Subject: R-6 Small Infill Design Review – 70 Anderson Street

Written by: Caitlin Cameron, Urban Designer

Date of Review: Wednesday, September 7, 2016

SHEET TITLE:
BUILDING A
FIRST FLOOR
PLAN

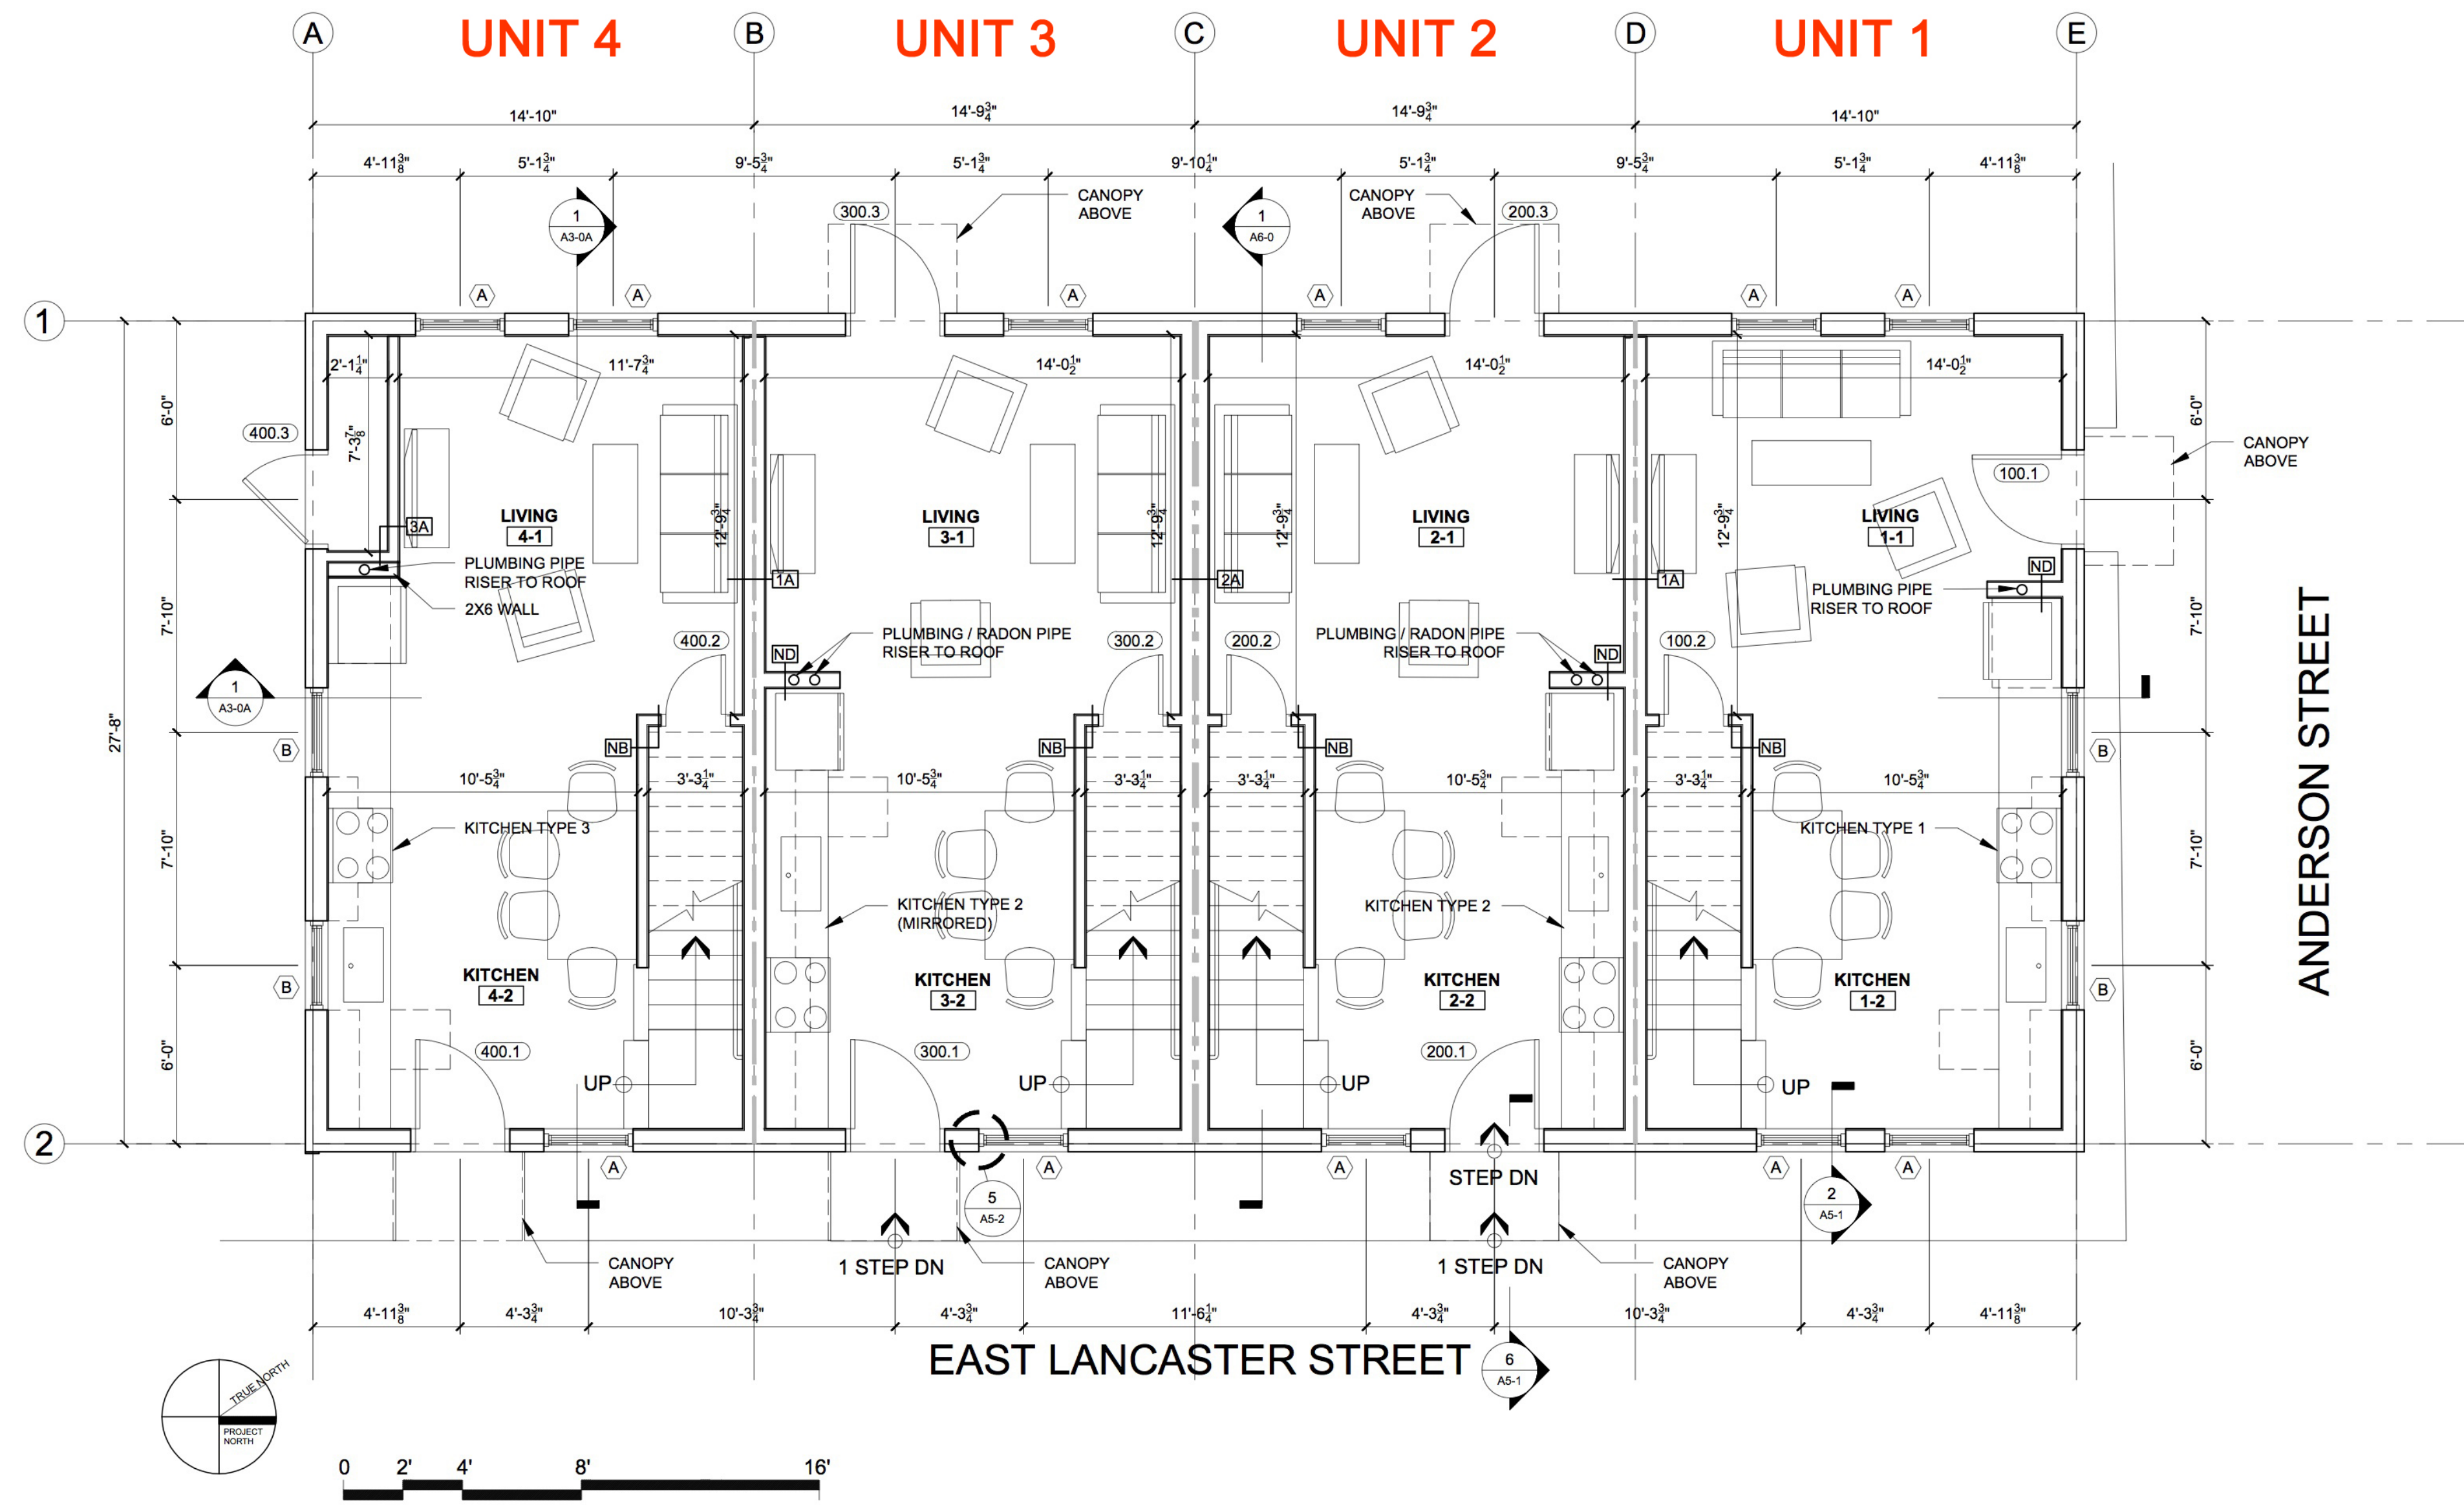
- *A-3 Relationship to the Street:* The building placement is consistent with the spacing of the residential fabric – slightly setback from sidewalk to allow for stoops and provide some privacy. **The ground floor does not appear to have been raised on Lancaster and the building entrances do not seem to have been subsequently raised. The primary entrances for the rowhouses should be consistently oriented to Lancaster Street but only two entrances now remain facing the street. The design is confusing – where are the primary entrances – why are they not all facing the same street?**

- *C-1 Entrances:* The entry to each unit is well-emphasized with the canopy.
- *C-2 Visual Privacy:* Visual privacy was addressed by shortening ground floor windows to be higher than 48” above adjoining sidewalk grade; **the street-facing ground floor is not adequately raised above sidewalk grade appropriate for private residential buildings with living space on the ground floor (at least 24” is required by the standard).**
- *C-3 Transition Spaces:* The project uses a canopy at each entrance but very little transition space is provided – **ground floor living spaces still have not been elevated on Lancaster Street.**

SOUTH WEST ELEVATION VIEW - BUILDING B

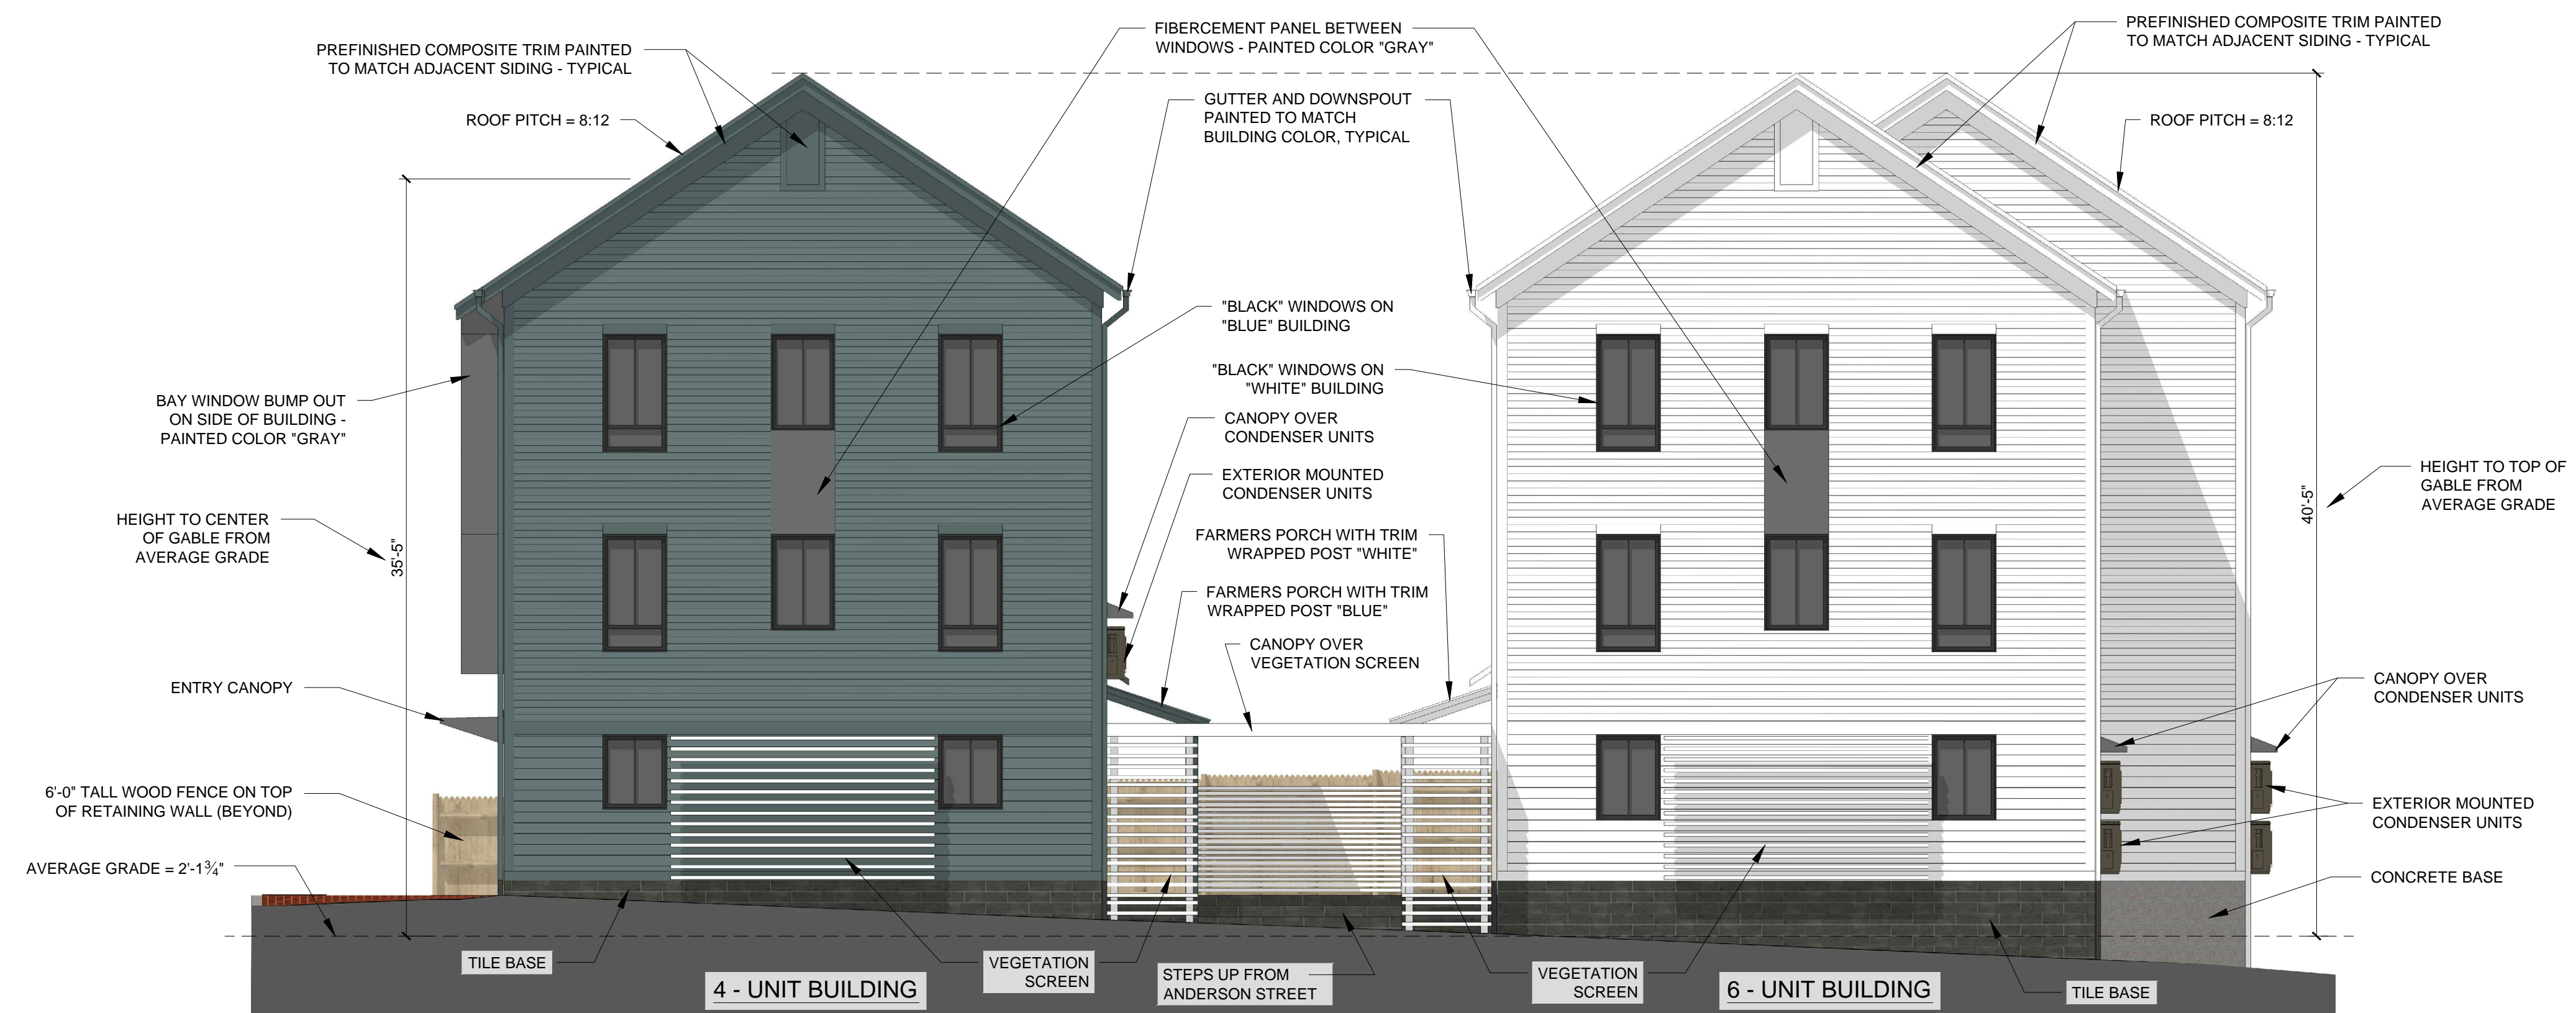
- *B-1 Massing:* The proposed mass is wider on the street than the typical building context but the use of row houses mitigates that massing.
- *B-2 Roof Forms:* **The gable roof was revised to have an 8:12 pitch and the trim details revised to create a more vertical proportion from the Anderson Street view.**
- *B-3 Main Roofs and Subsidiary Roofs:* Met – there is a clear main roof form.

- *B-4 Roof Pitch:* The standard requires gable roofs to have a slope between 7:12 and 12:12.
- *B-5 Façade Articulation:* The project revision employs two of the required articulation elements – covered entries and bays. **Bays were added to both Lancaster and Anderson Streets to meet the standard.** However, the bays on Anderson are out of proportion to the overall façade and should either be enlarged or removed altogether (for this project Anderson is the “B” street). The previous canopy profile was preferred over the one now proposed which is incongruous in character with the building architecture. The connected “porch” canopy interior to the block is not appropriate for individual rowhouses.
- *B-6 Garages:* Not applicable.

- *F-3 Visual Cohesion:* The visual cohesion of the façade is good **with the exception of the canopy profile and “porches” – the designs are incongruous with the rest of the buildings. Porches should be replaced with individual canopies.**
- *F-4 Delineation between Floors:* The first floor is delineated through trim and change of clapboard reveal.
- *F-5 Porches, etc.:* The stoop and canopy are well integrated into the overall design.
- *F-6 Main Entries:* The main entry is emphasized with prominent placement facing the street, the use of a canopy.
- *F-7 Articulation Elements:* It appears the rake of the roof meets the 6” requirement; the trim details are not clear; there do not appear to be offsets in the principal façades.

- *G-1 Materials:* The residential context is predominantly clapboards with occasional shingle or brick – **base should be brick, not tile.**
- *G-2 Material and Façade Design:* The materials are appropriately placed according to their nature **with the exception of the fake bricked-in doors on Anderson which should be removed and returned to clapboard.**
- *G-3 Chimneys:* Not applicable.
- *G-4 Window Types:* Two window types.
- *G-5 Patios and Plazas:* Internal plaza space uses stone steps and a concrete brick paver with rain garden and planting areas.
